Application No: EP/16/21/PL
Site Address: Land East of 1 The Way East Preston BN16 1QJ
Description of works: Replacement garage. This site is in CIL Zone 4 (Zero Rated) as other development.

Thank you for your internet representation made on 10th March 2021 which has been recorded as an objection with the comments as follows:

Client: Mr D Lynch		
Project Address: The Garage The Way East Preston		
Drawing Title: Existing and Proposed Plans and Elevations		
Drawing Number: 1241.01.g		
Scale:	As stated printed @ A1	
Date:	06/01/2020

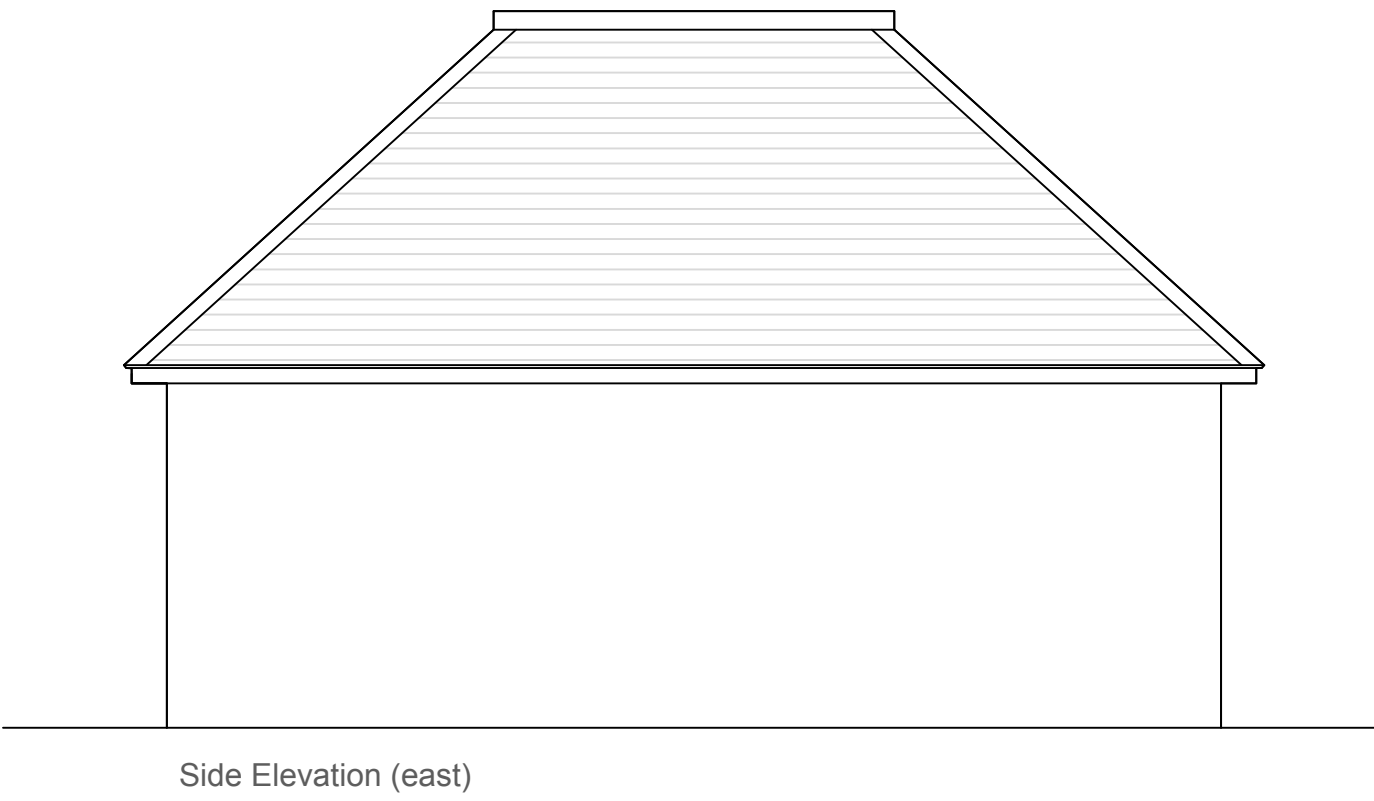
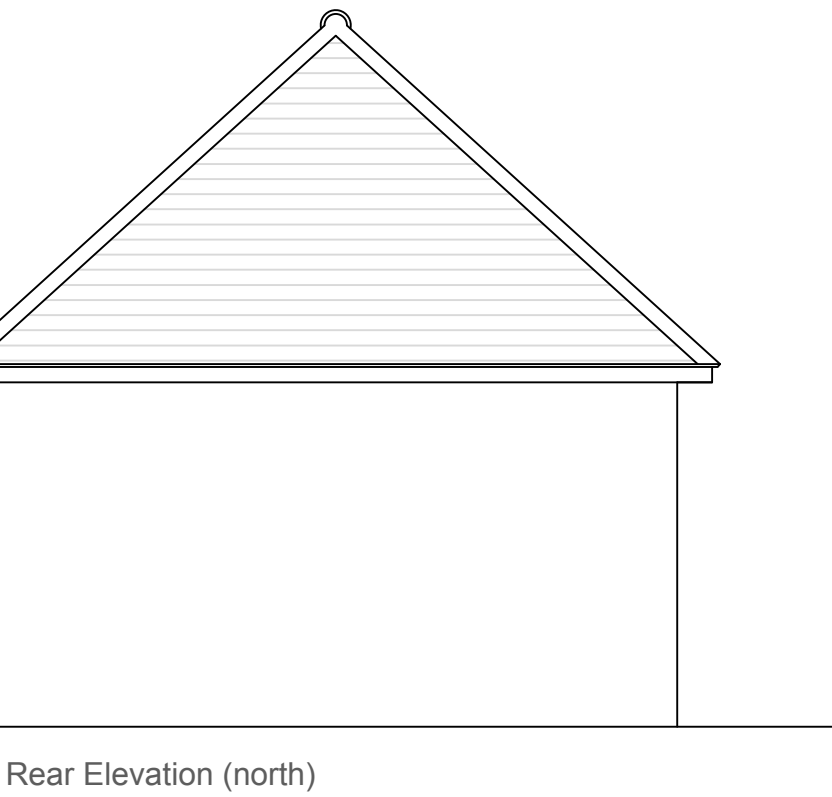
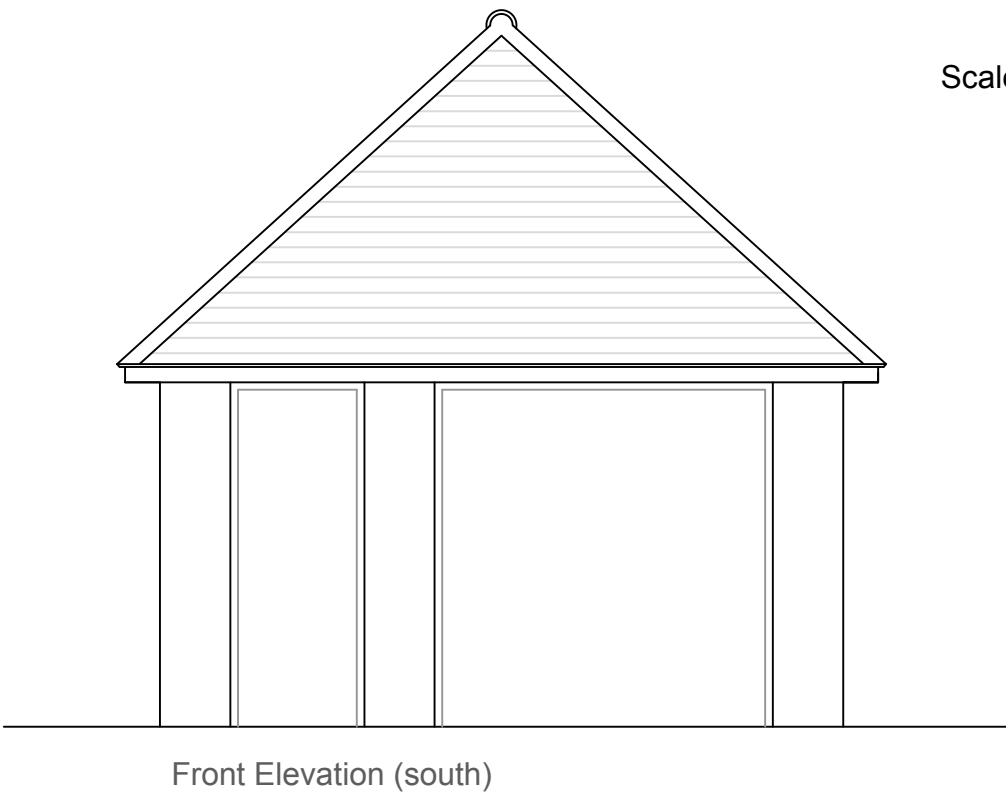
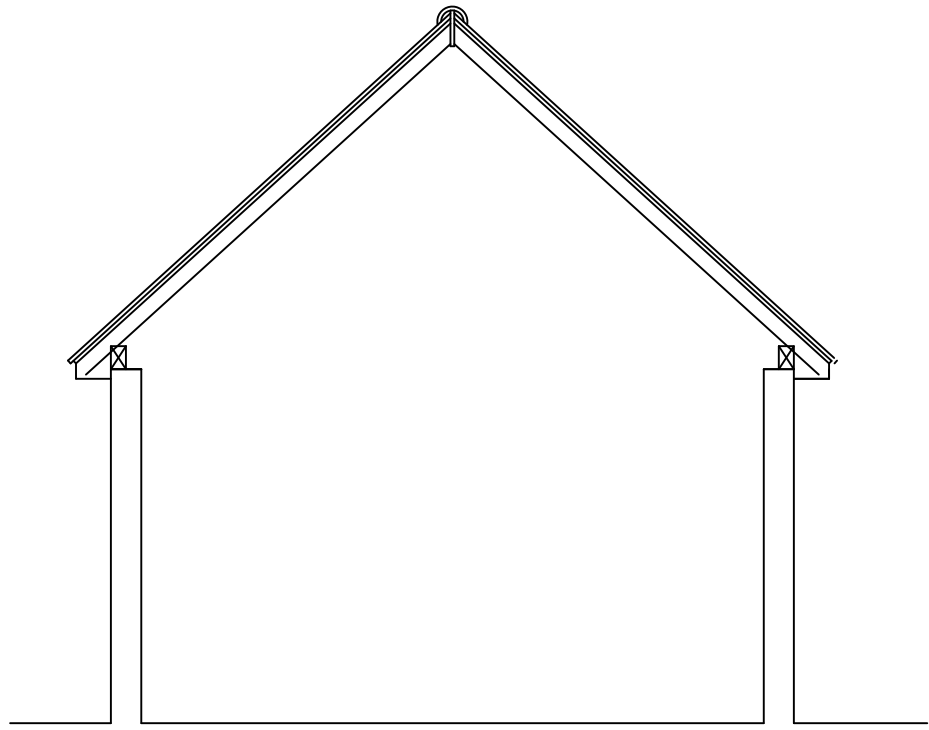
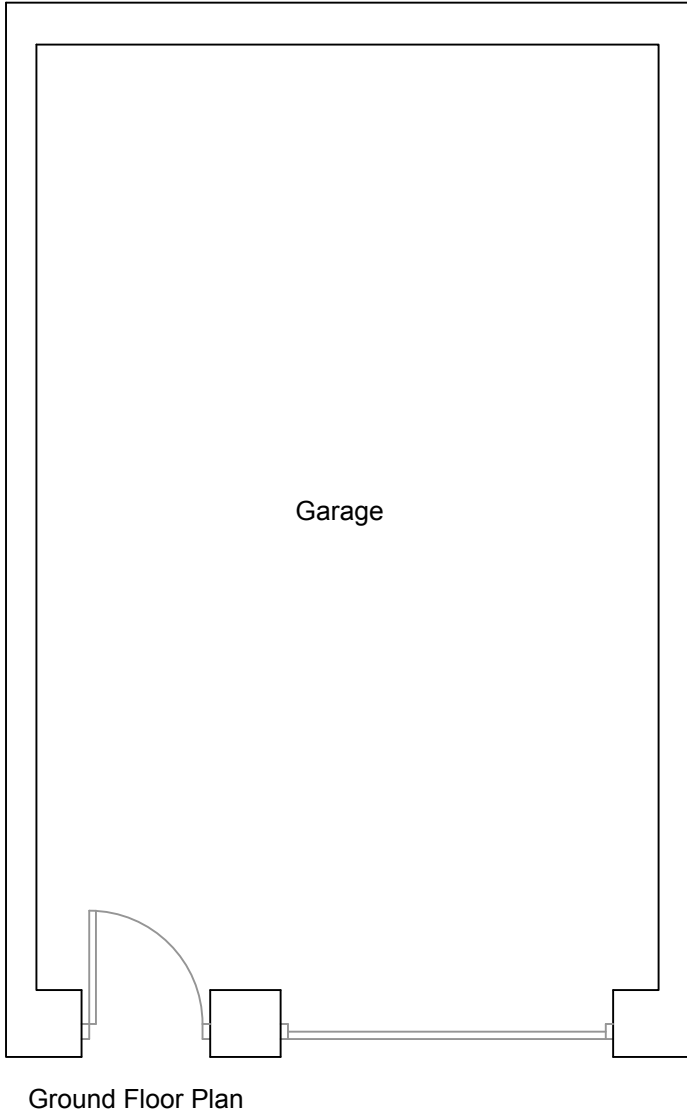
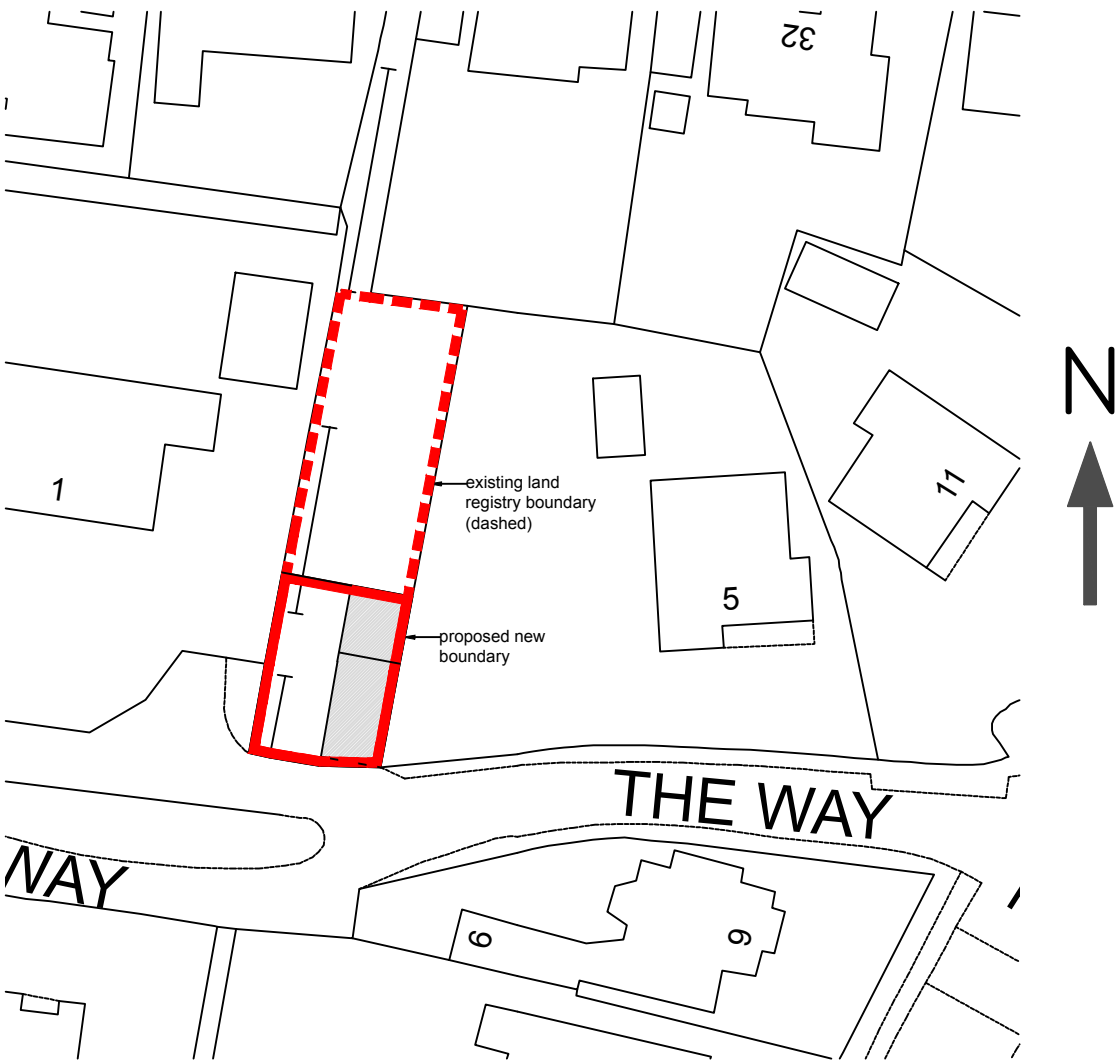
I note the above proposed plan seeks to build a new garage more or less where the existing garage has stood for a long time. I understand that the plans for the new garage will make it about three quarters of a metre taller and that the elevation on the South side will be vertical to the top rather than as a hip angled to the north and also that a window will now be included in the South elevation.

My objection to the plan is that The Way is a narrow road with an island in the middle portion and a vertical south elevation will be out of character with the rest of the properties on the Way which are set back from the curve. In addition with the window in the south elevation we will lose all of our privacy in the whole of our back garden which we have enjoyed for many years. We are not sure why a garage needs such a window and if it does then we would request that opaque glass be a stipulation of the planning consent.
